SCIENTIA PROJECT - MONTE SANT ANGELO MERCY COLLEGE (SSD- 10393)

**RESPONSE TO
SUBMISSIONS**

18 August 2020

SUN STUDY 9AM

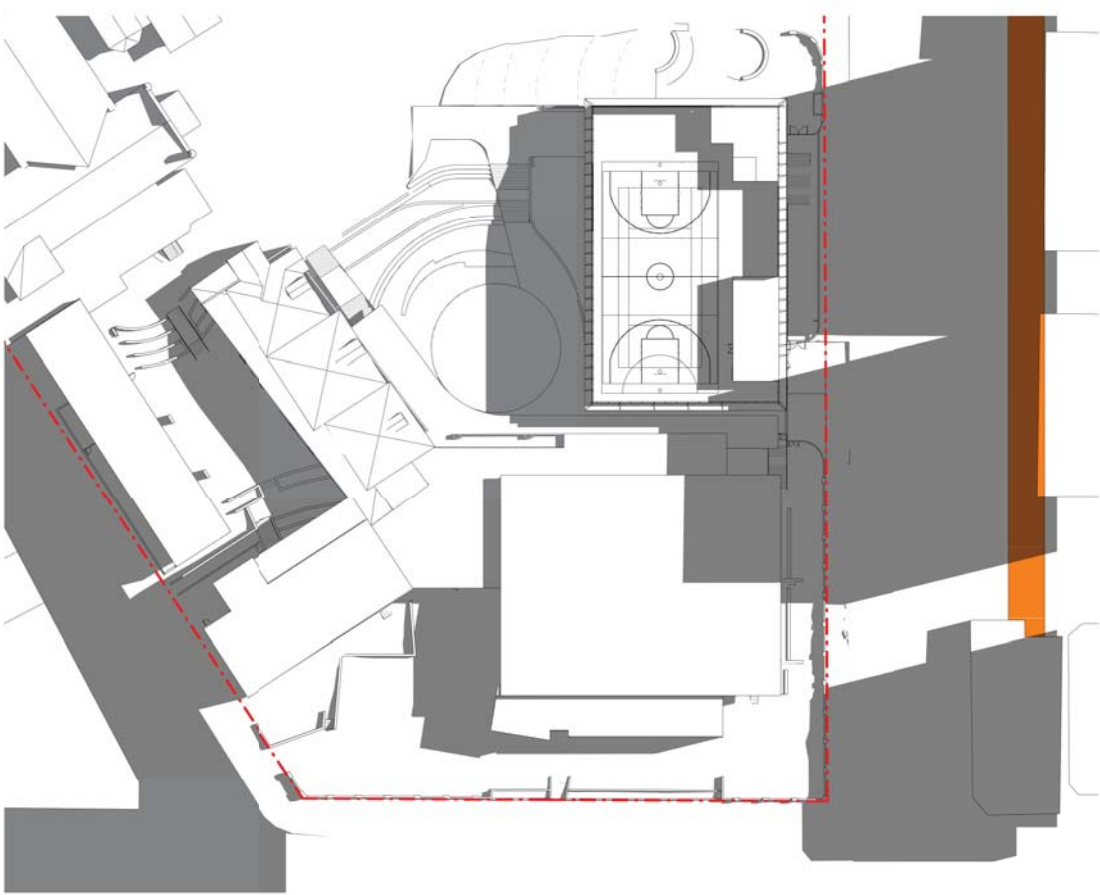
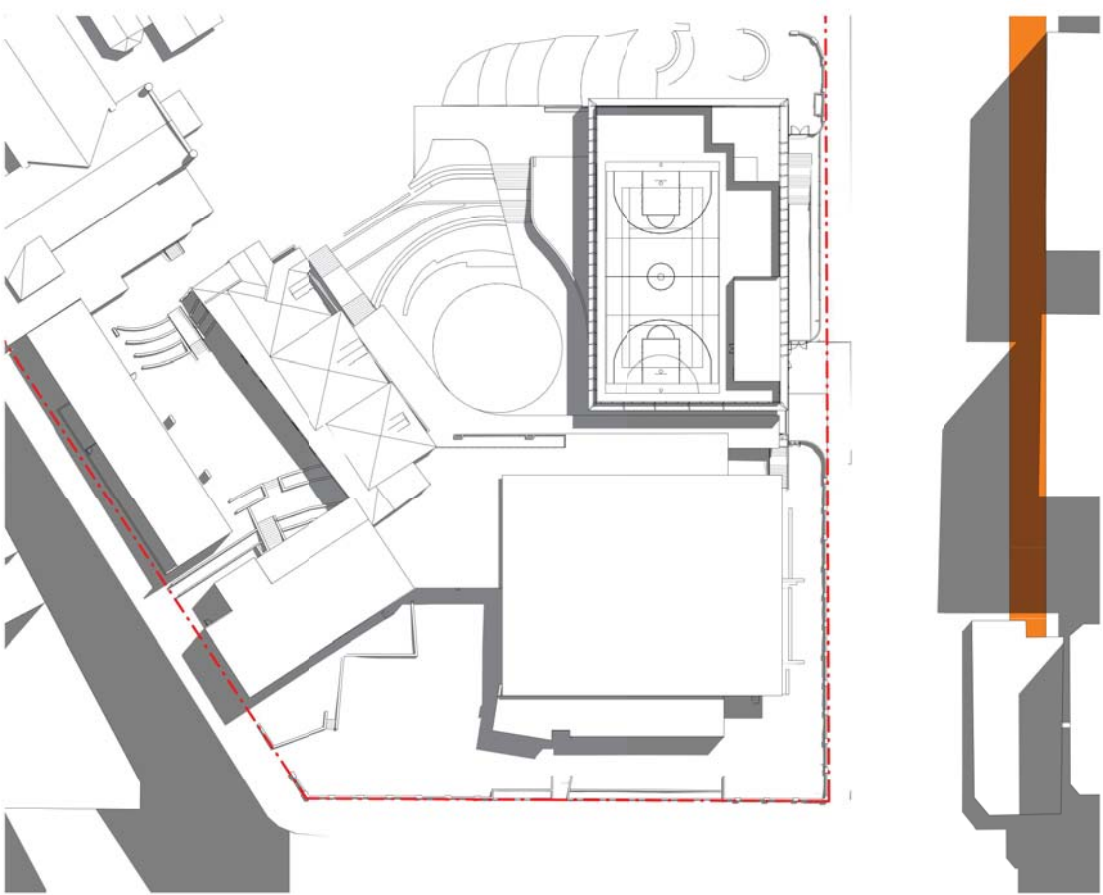
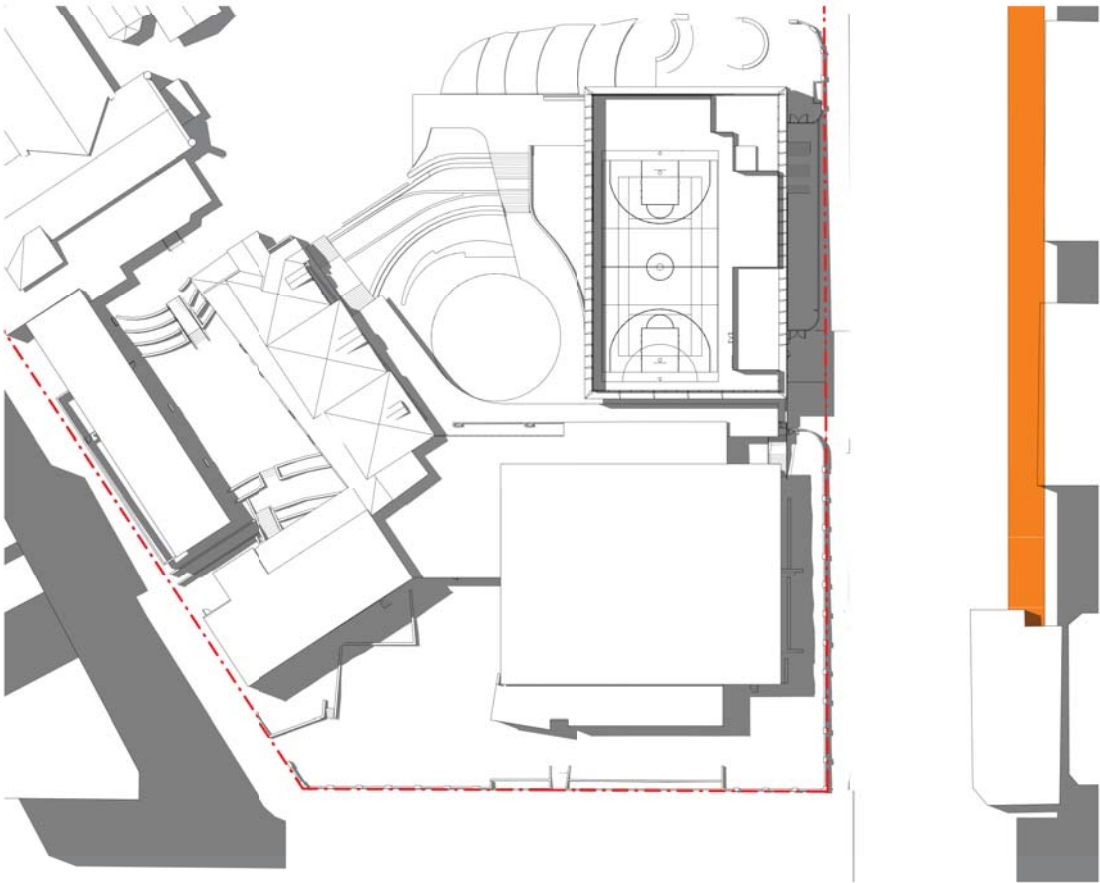
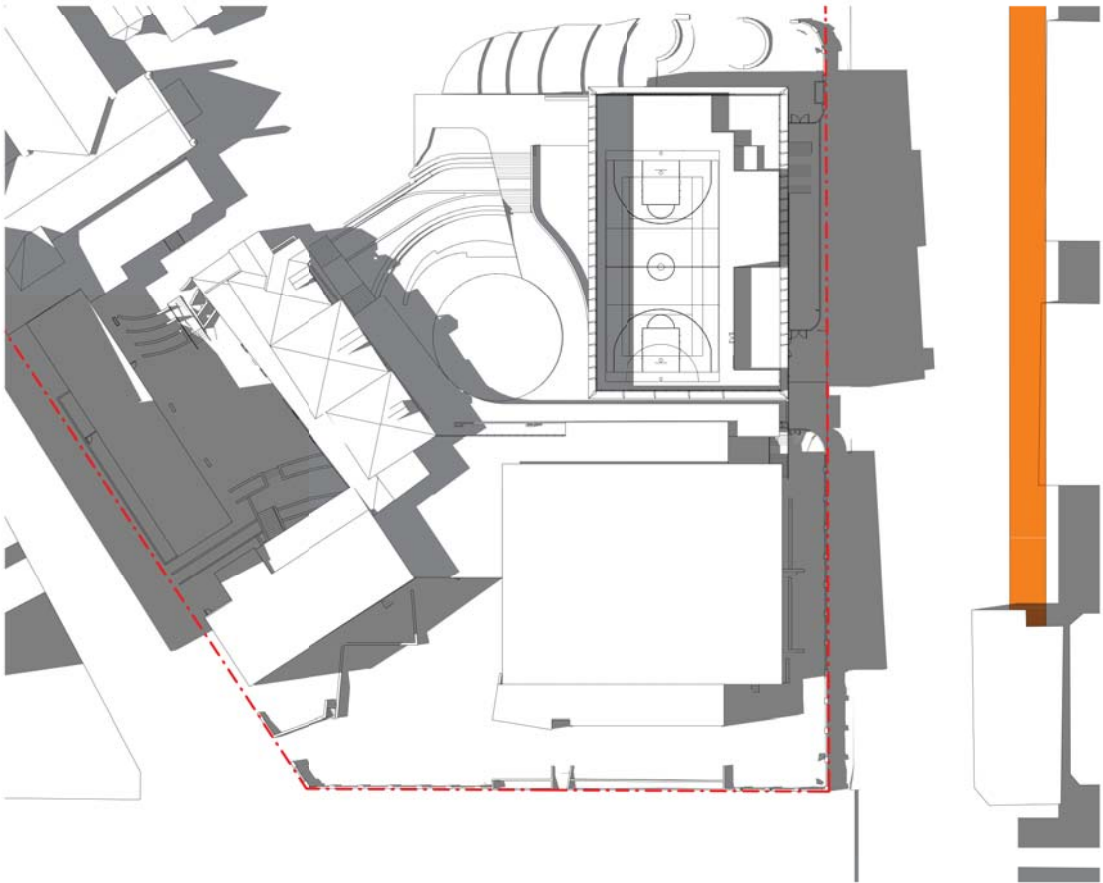
Submission	Comments/Report Reference
The eastern side of Miller Street adjacent to the subject site contains a 'Special Area' in accordance with the NSLEP2013. Whilst the submitted shadow diagrams do not detail any overshadowing during 12pm - 2pm, it is unclear whether any additional overshadowing will occur outside these times to the Special Area. It is considered that any overshadowing to this Special Area, resulting from a breach to the building height control, is unacceptable. Plans must ensure there is no overshadowing impacts to the Miller Street special area.	equinox to September equinox (inclusive). Accordingly, the proposal can comply with Clause 6.3 of LEP 2013. In addition to the LEP provision, as requested by Council in the post exhibition meeting, additional shadow impact have been assessed to demonstrate the impact to the 'Special Area' after 3pm. Please note, the assessment has been provided for reference only and it does not change the proposal's compliance with Clause 6.3 of LEP 2013. As indicated in Figure 7 and Section 3.3.1, the proposed building will not overshadow the 'Special Area' at 3pm in March and September Equinoxes. However, it will create additional overshadow to the 'Special Area' at 3pm in winter solstice in comparison to the existing shadow from the street trees. Furthermore, it is important to note that a compliant building envelope (16m) would also overshadow the 'Special Area' at 3pm in winter. Accordingly, the impact is deemed acceptable and it is outside the compliance requirement of Clause 6.3 of LEP 2013. Detailed shadow diagrams are contained within Appendix B.

<u>Overshadowing Impacts</u>	Revised shadow diagram has been prepared to demonstrate that the revised scheme, including the rooftop court net will not create net increase in overshadowing to the 'Special Area' between 12 pm and 2 pm from March
